BUILDING CODE OF AUSTRALIA CAPABILITY STATEMENT - Rev A

Property: Sydney Opera House – DA2 Submission

- **Joan Sutherland Theatre Accessibility**
- **Joan Sutherland Theatre Follow Spot Room**
- **Eastern Accommodation**

BCA Assessment (Joan Sutherland Theatre Follow Spot Room Project ONLY)

7 RCP - FOLLOW SPOT ROOM - DA
1 : 50

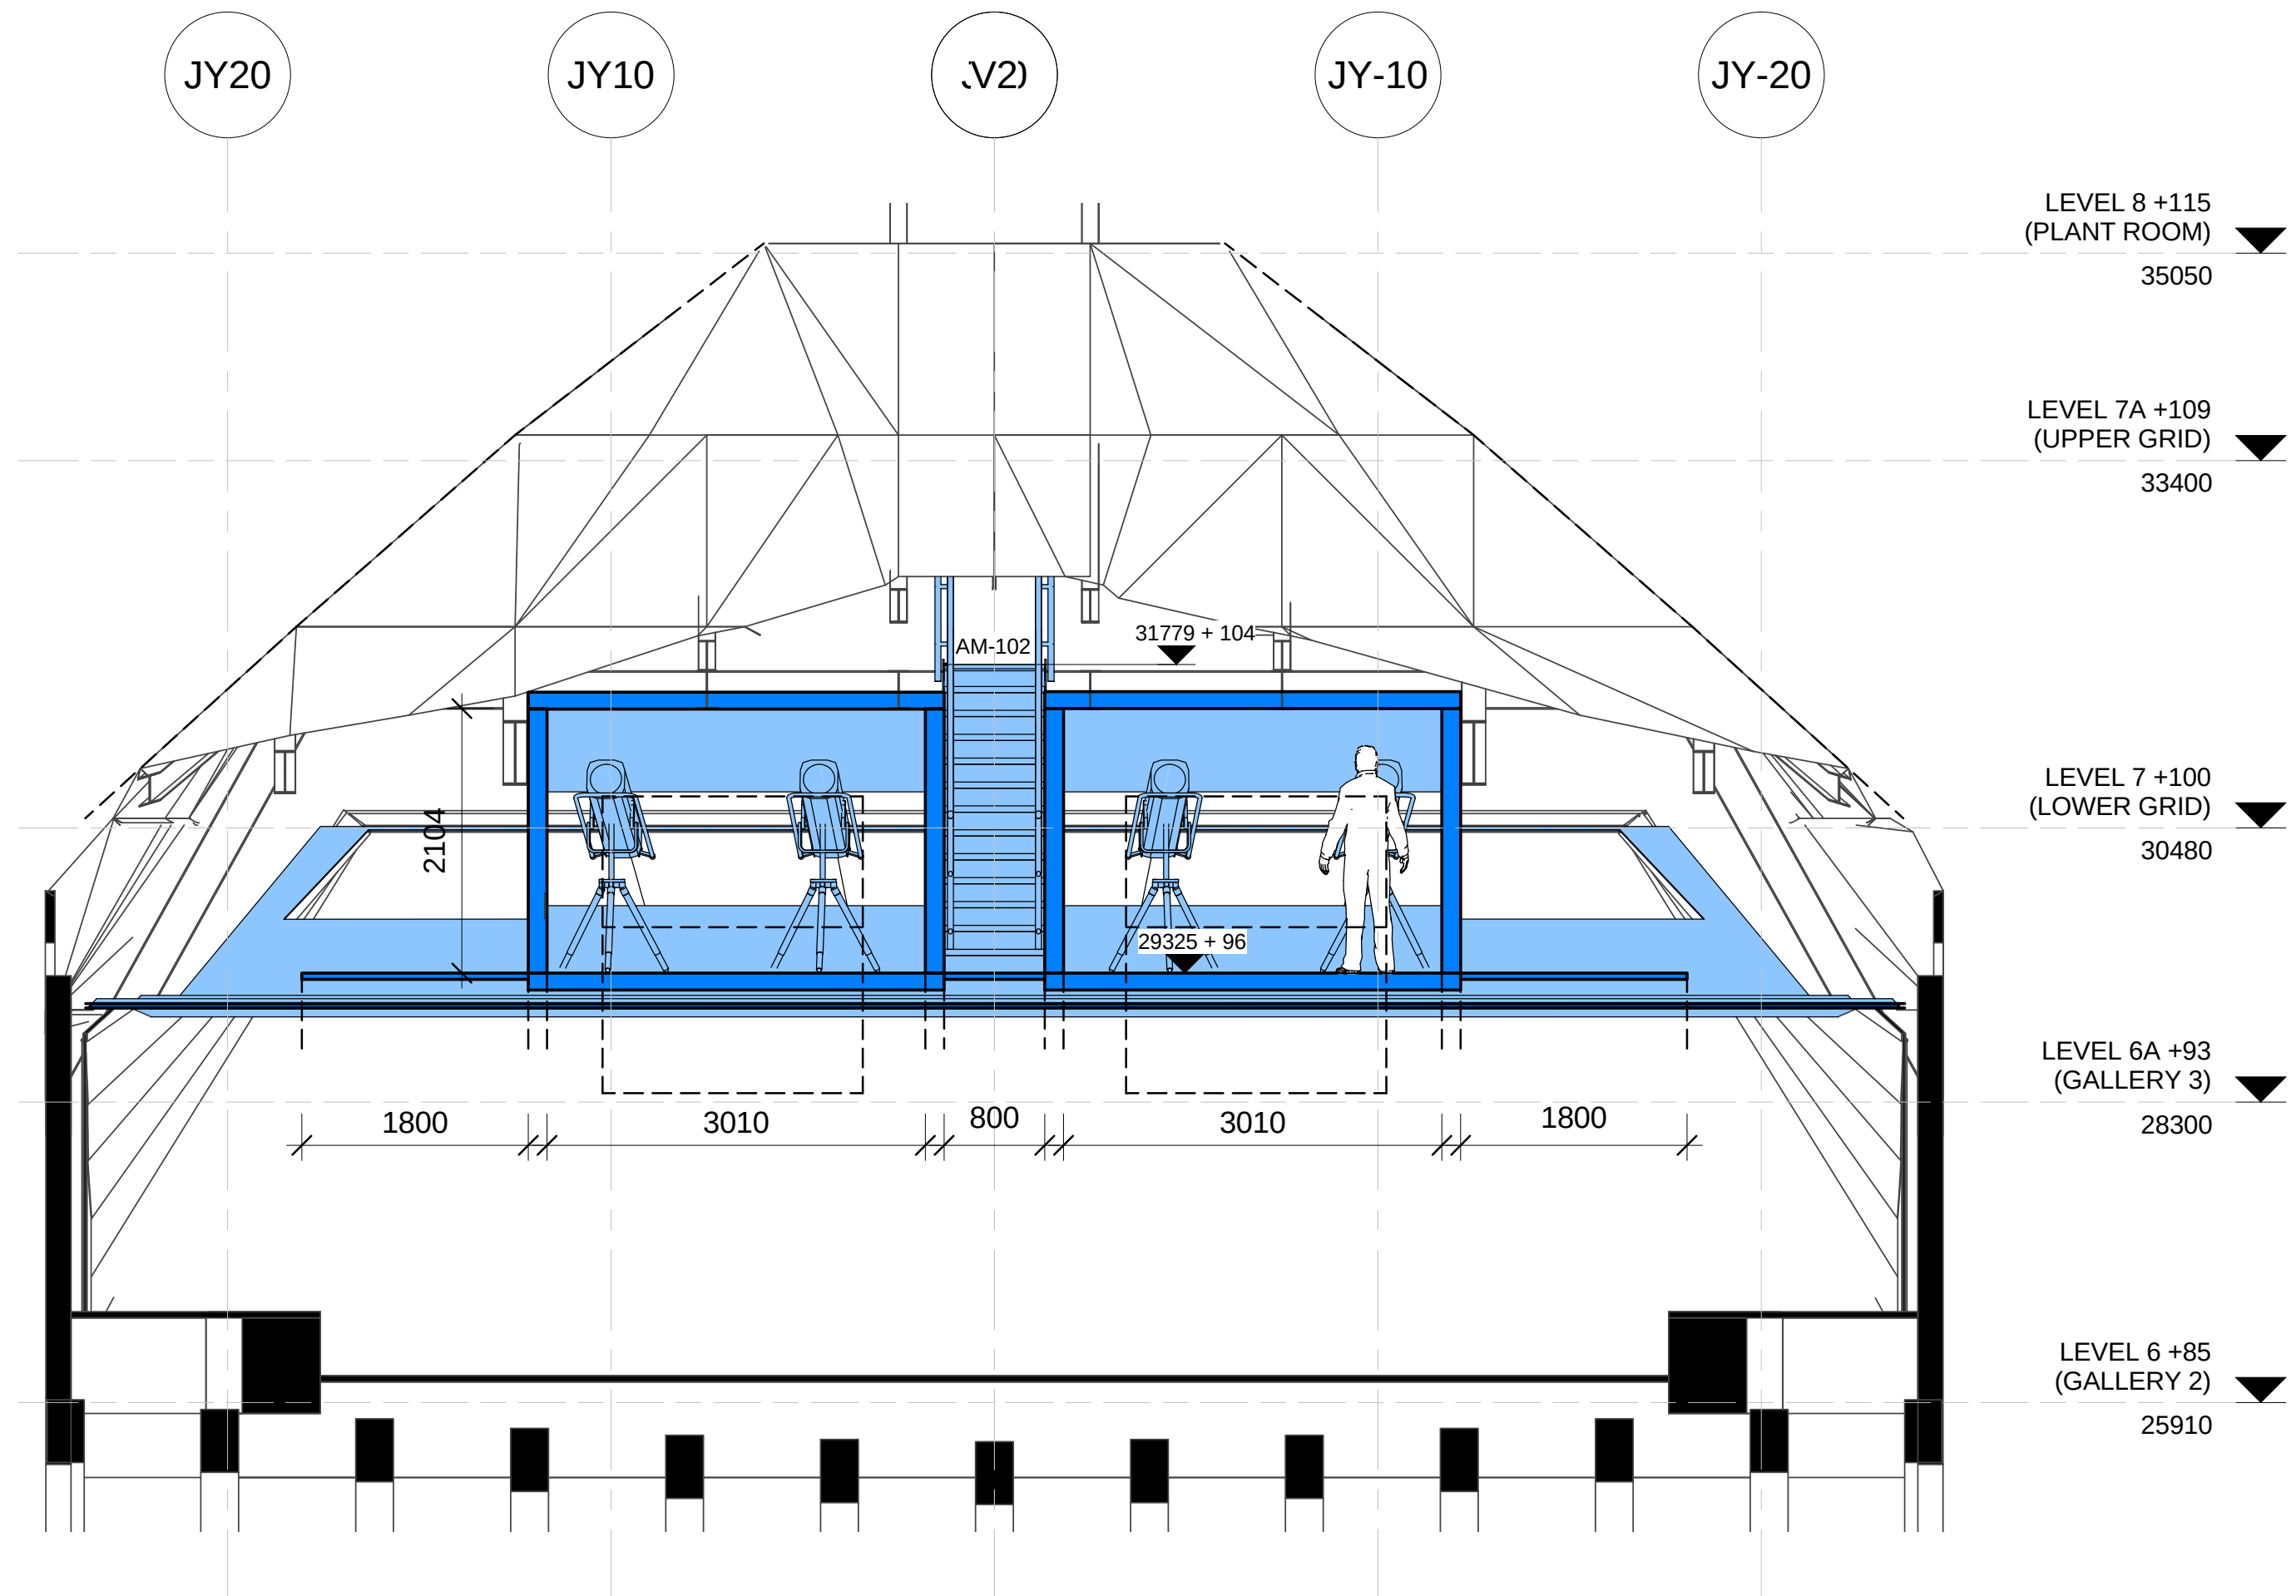
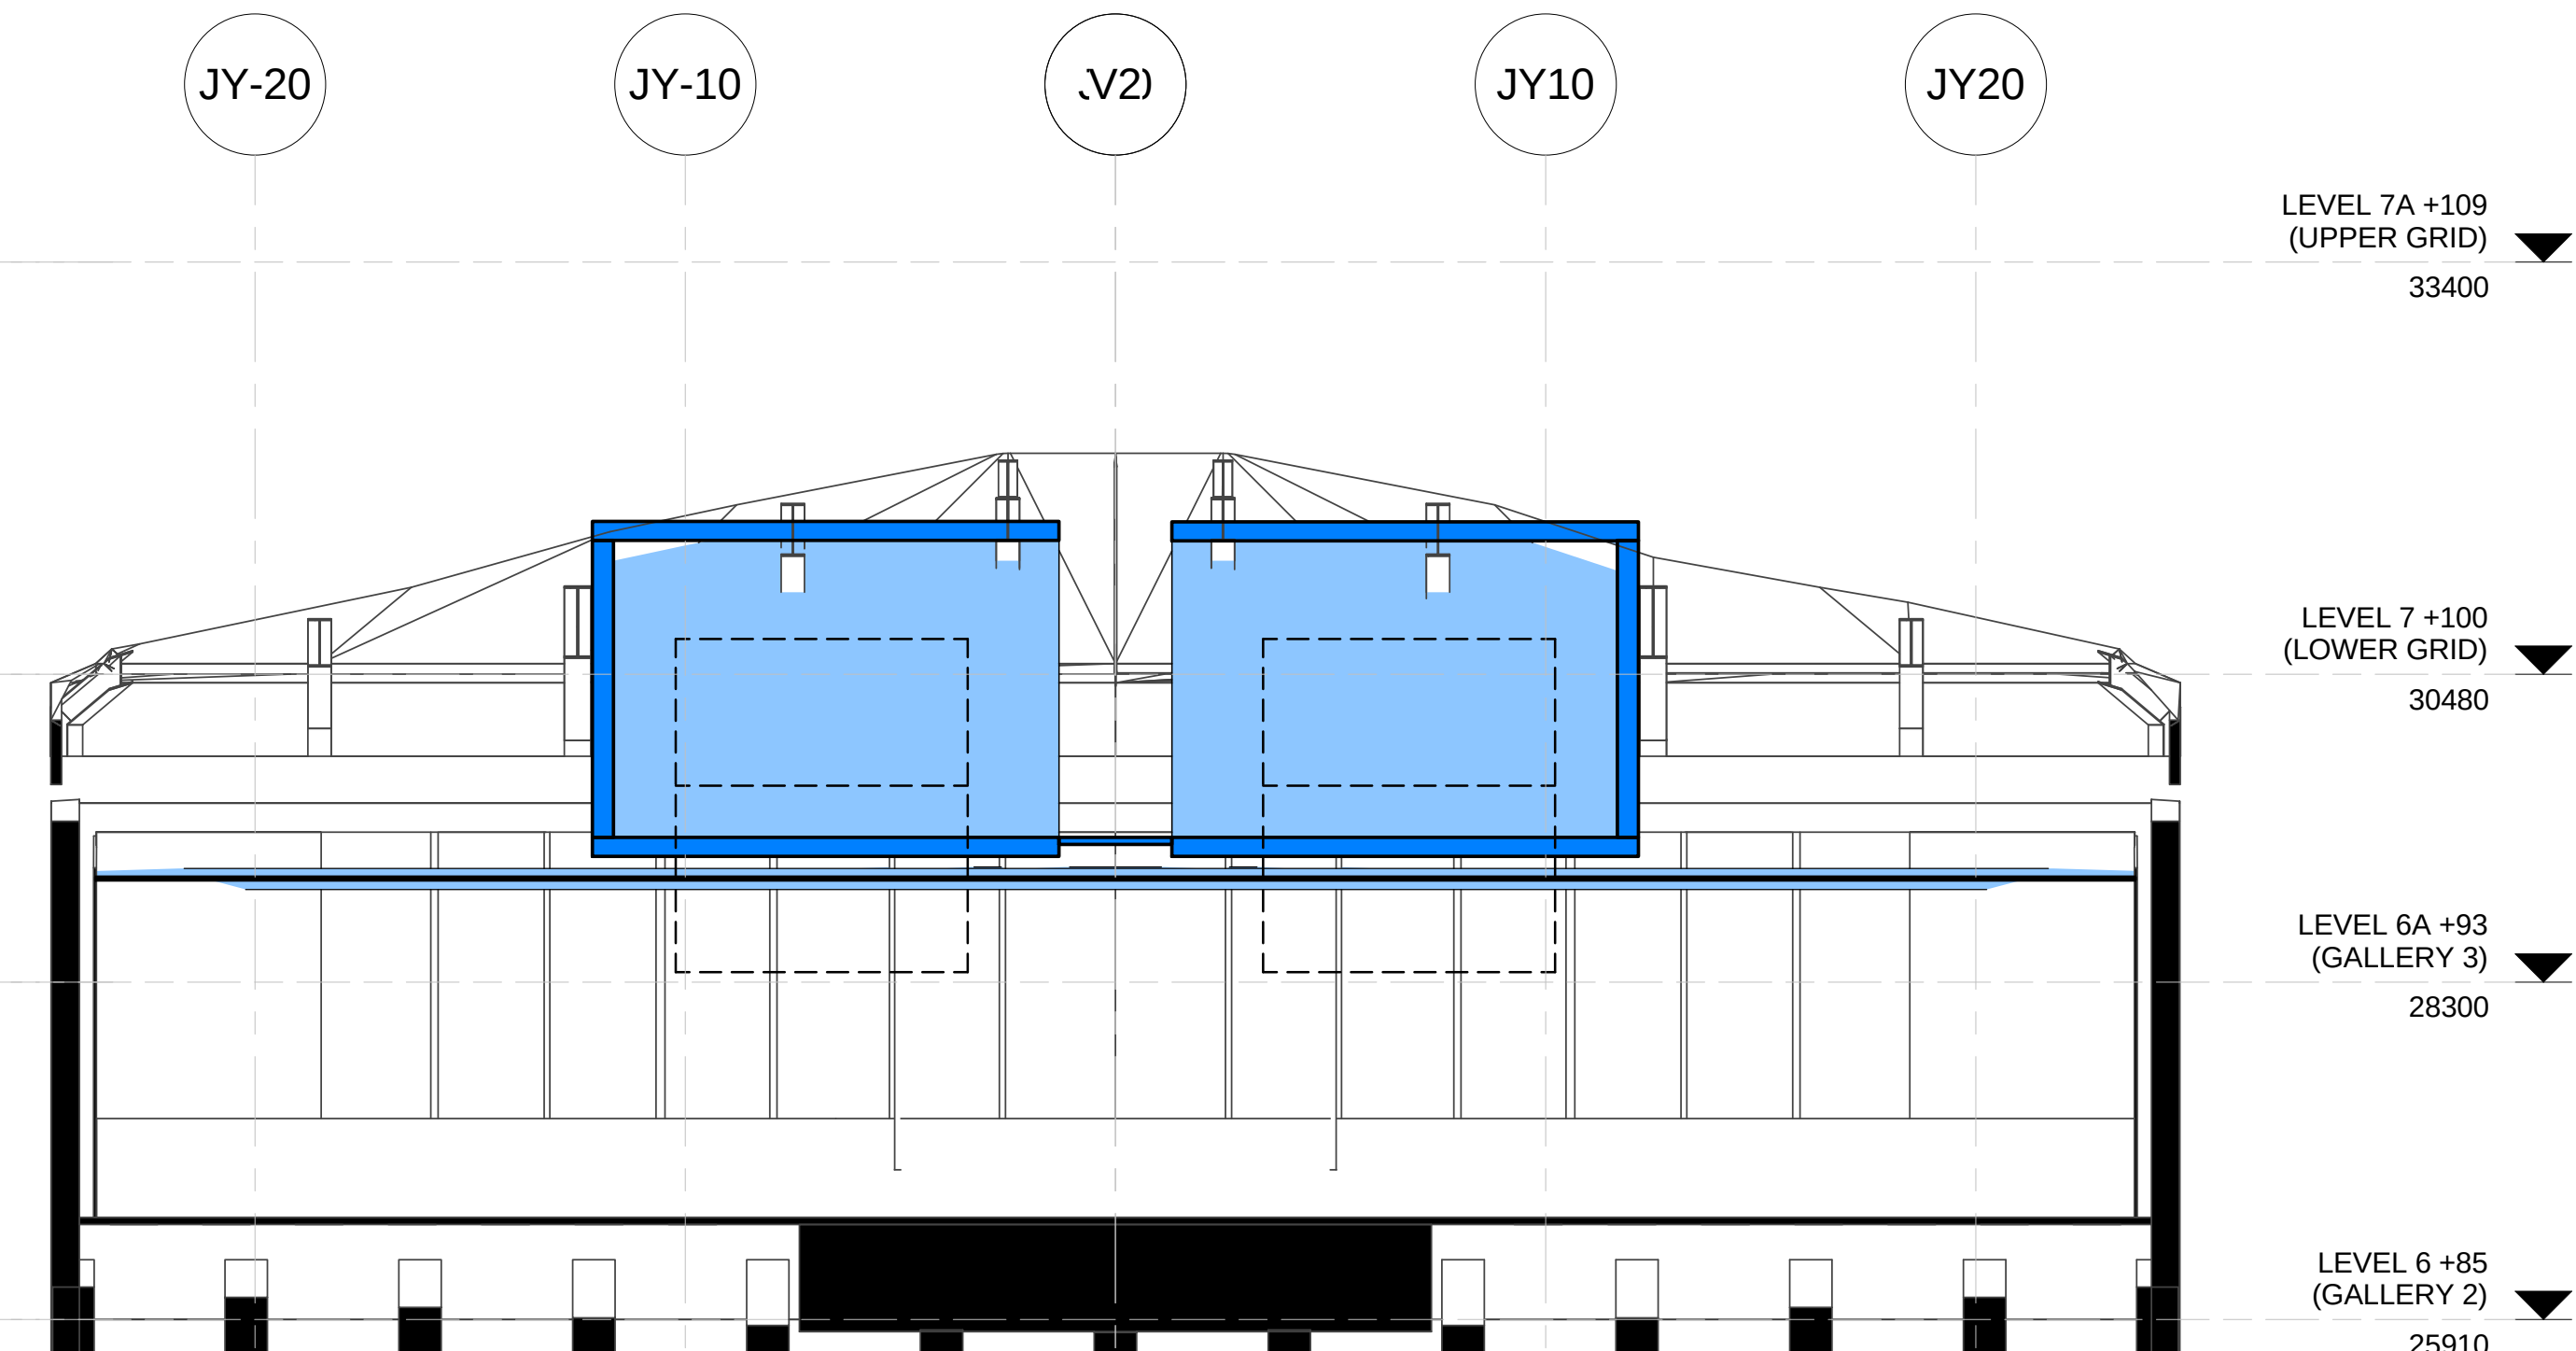
The new floor to the Follow Spot Room is required to be constructed from non-combustible materials and contain an FRL of 120/120/120, or a Performance Solution from the Fire Safety Engineer will need to be considered. The plans illustrate a fire rated plasterboard arrangement consisting of 2 layers of 16 mm Firecheck, the manufacturer and the systems number is required to be nominated for further assessment, i.e. CSR Red Book Version 2 system Number SYS106.

Only one exit from the existing and proposed Follow Spot Rooms is proposed where no less than two are required. The Fire Safety Engineer will need to consider the feasibility of a Performance Solution. It is understood that the area in question will have low number of trained staff present at various times.

The new steps, balustrade and Portal Openings are required to comply with AS 1657-2013.
